Appeal Decision

Appeal Ref: APP/R4408/W/21/3269533

7 Claycliffe Avenue, Redbrook, Barnsley S75 1HJ

- The appeal is made under section 78 of the Town and Country Planning Act 1990 against a refusal to grant planning permission.
 - The appeal is made by Mr Christopher Goldie against the decision of Barnsley Metropolitan Borough Council.
 - The application Ref 2020/0434, dated 24 April 2020, was refused by notice dated 18 December 2020.
 - The development proposed is construction of a new detached bungalow.
-

Drawing Title **PROPOSED ELEVATIONS**

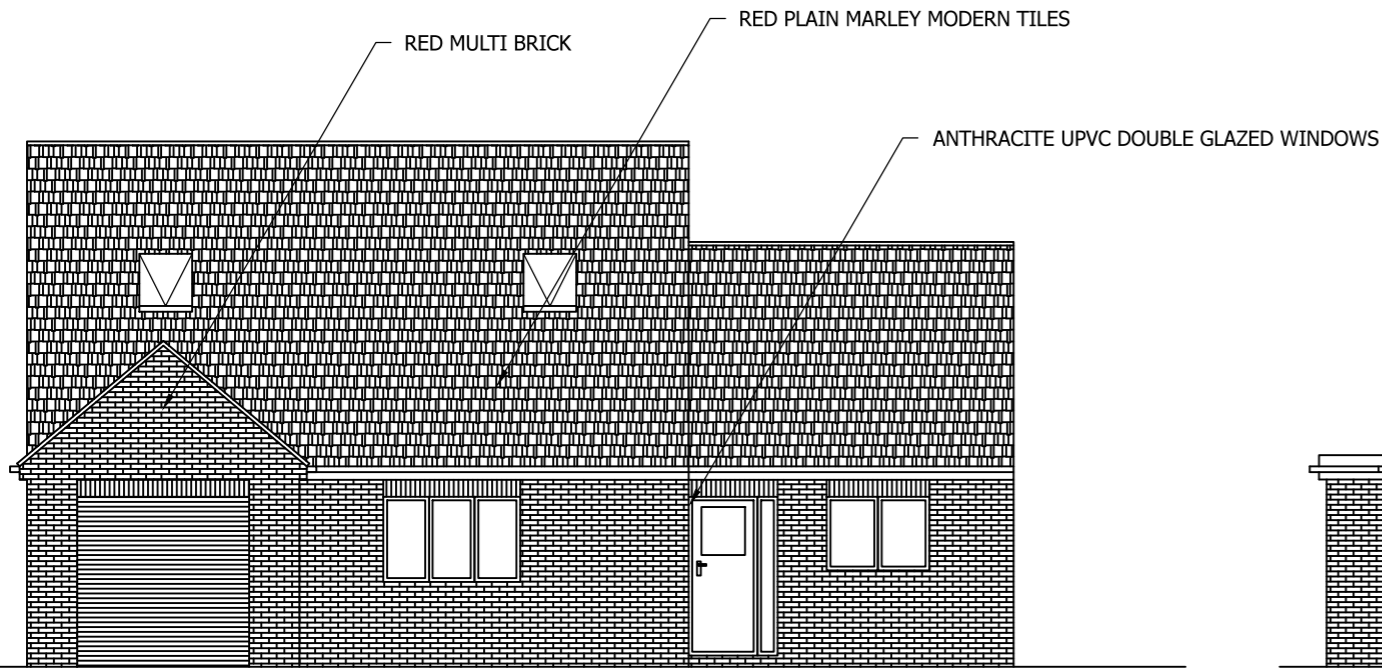
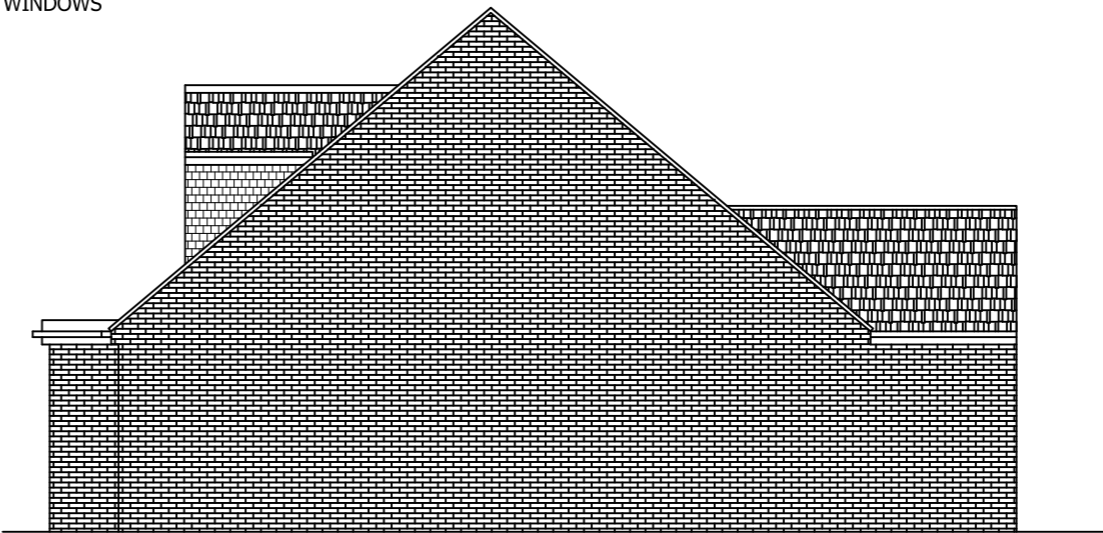
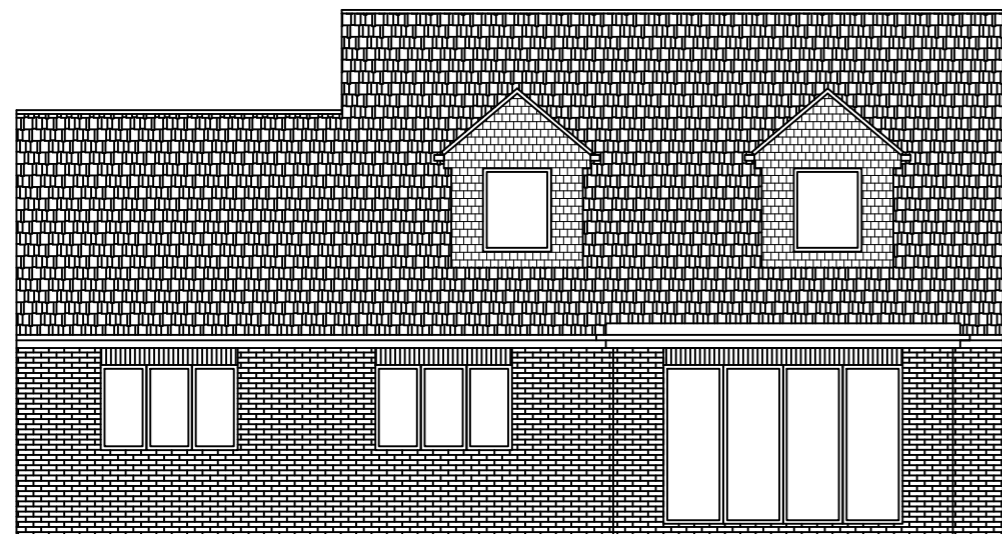
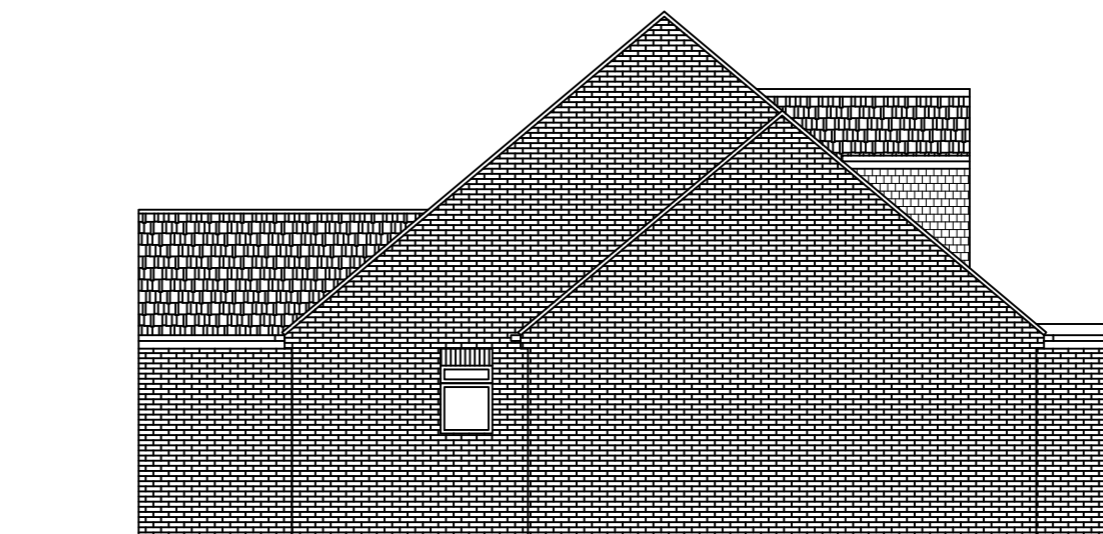
6. However, I find that the design of the dwelling would look incongruous in the area. In order to accommodate the rooms in the roof space, the roof pitch is quite steep, which from an external view, creates a large expanse of roof area, and does not sit well within the immediate locality of dwellings of a more traditional design, albeit with some variations in the materials palette.

7. I have noted the comments of the appellant in relation to the nature of surrounding development, and the design of the single-storey dwellings, but I find these are also more traditional in design, with a significantly lower roof pitches and as a result, less of an external roof profile, more in keeping with their surroundings.

8. The steep roof pitch would give the property, ostensibly a single-storey dwelling, the overall height akin to a two-storey dwelling. This would look at odds with the simple designs and perspectives of nearby property and magnify its incongruous nature in the street scene. There is no doubt that a dwelling can be accommodated on the site, with more than enough space to give appropriate levels of parking and private amenity space, whilst respecting the privacy of nearby residents, with an appropriate design that respects the character and appearance of the area.
